**Natural England's End of Examination Position on the Applicant's Proposed
Compensatory Measures**

The construction and operation of Hornsea Project Four Offshore Wind Farm, located approximately 69 km from the East Riding of Yorkshire in the Southern North Sea, covering an area of approximately 468 km².

Planning Inspectorate Reference EN010098

10th August 2022

Figure 1: Potential topside design.

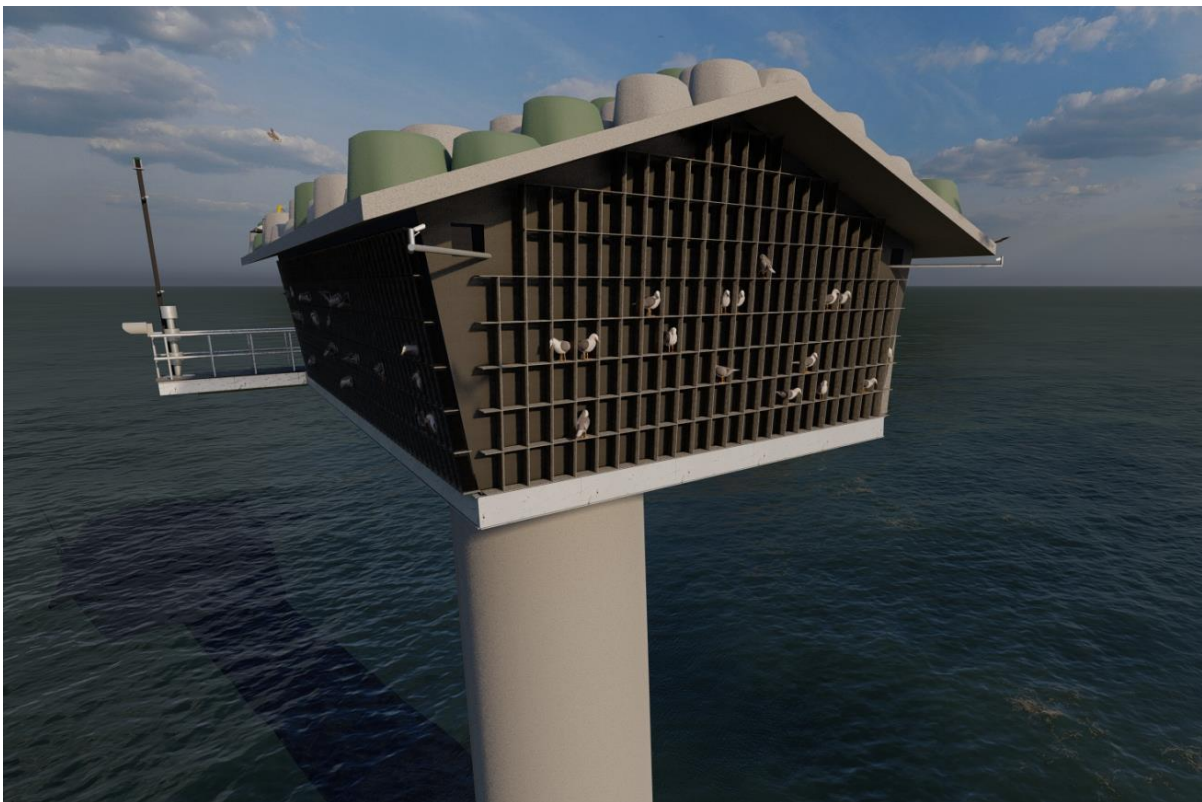
Natural England's primary concern with this measure remains that a commitment has only been made to provide a single structure. We consider this to be high risk, particularly for a new structure. Multiple structures 'spread the risk' of non-colonisation. We note that the compensation proposed and accepted by SoS for Hornsea Three included the provision of four structures in at least two locations, each capable of compensating for the predicted impact at a 1:1 ratio, as a way of managing this risk. We welcome that the Applicant has increased the lead in time to three years prior to operation but note that this remains less than the four years consented on other projects, and that the Applicant also now suggests that a timescale need not be conditioned at all [REP5-017]. We do not consider that this approach (both in terms of lead in and number of structures) would afford the Secretary of State sufficient confidence that the compensation would be delivering prior to impact

Figure 3 Proposed new structure refined search area and preferred repurposing option location with heatmap analysis.

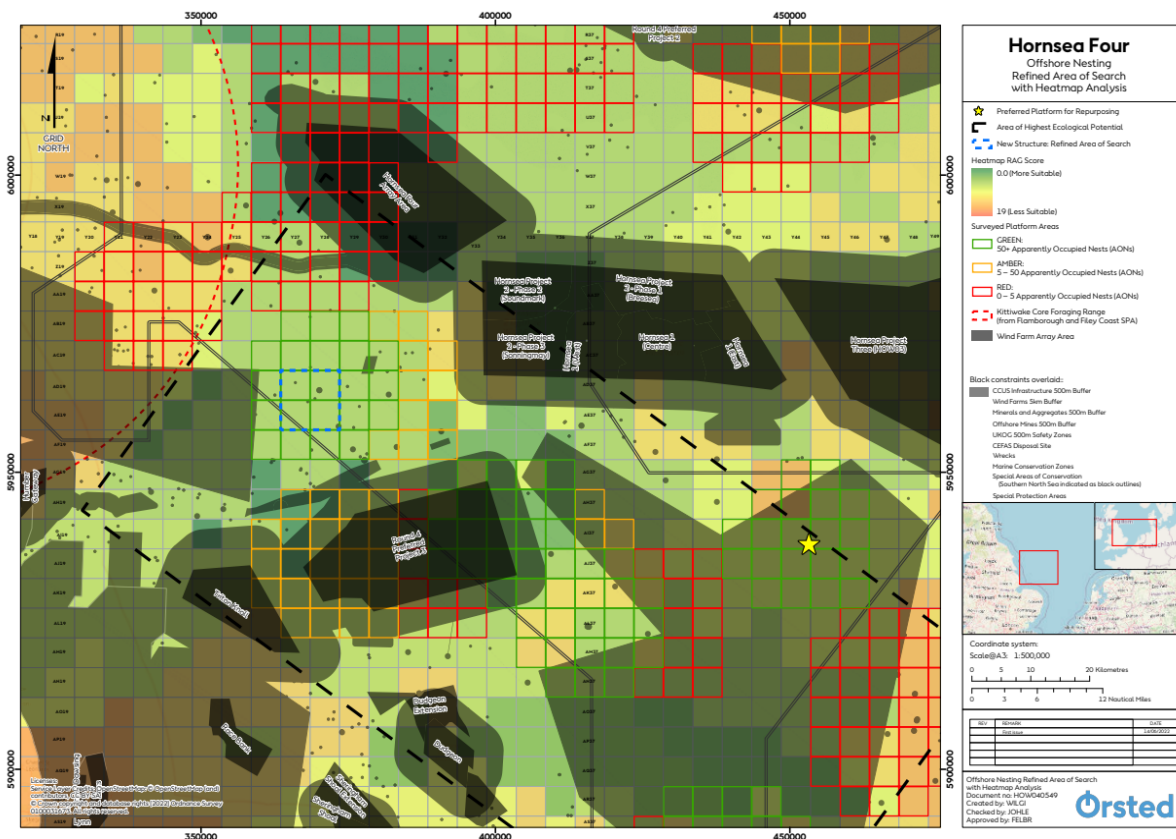
The results of targeted survey effort have been provided and a location for a repurposed platform has been identified. The Applicant has been proactive in progressing the necessary pathways for securing the structure; however, it cannot yet be considered secured. We also understand that the regulator of oil & gas structures (BEIS OPRED) has concerns about the acceptability of this measure should it relate to repurposing such a structure. The identified structure is located within the North Norfolk Sandbanks and Saturn Reef Special Area of Conservation (NNSSR SAC) which is in unfavourable condition. Further discussion will therefore be needed on the implications of this development for the designated site, which has unfortunately not been possible in the Examination. A location for a new structure has not been identified and/or secured as the Applicant's preference is to repurpose a structure, however a search area of high suitability has been identified using best available evidence.

Location of measure	A comprehensive spatial mapping exercise considering agreed search criteria has been undertaken and revealed areas of high suitability. A structure for repurposing has been identified, however it is not yet secured and is located within the NNSR SAC. Further discussion will be needed on the implications of the measure for the designated site. A search area for a new structure has been identified but a final location has not been identified/progressed as the Applicant's preference is to repurpose a structure.
Long term implementation	We remain concerned that the provision of a single structure does not build in resilience over the lifetime of the project. Adaptive management will be more difficult offshore, and the provision of a single structure increases the likelihood of it being needed. Remote monitoring may be possible, but data quality will need to be evidenced.
Success criteria/Ability to prove additionality	<p>As nest availability has not been proven to be a limiting factor, new colonies will need to have increased productivity to deliver additionality.</p> <p>Additionality will also depend on whether new or repurposed structures are implemented. If existing colonies (i.e., decommissioned structures) are being maintained additionality must be carefully considered, as should possible consolidation of small colonies across numerous existing structures onto a new structure that may prove to be more attractive to nesting birds. Maintaining a colony with no productivity increase or relocating existing breeding birds would not deliver compensation.</p> <p>To account for this, monitoring efforts will need to be wider in scope than just the artificial structure, and the current understanding of existing offshore colonies and their productivity will need to be built on prior to implementation of the measure to fully evidence the additional benefit of a new or repurposed structure. This will be challenging offshore.</p>
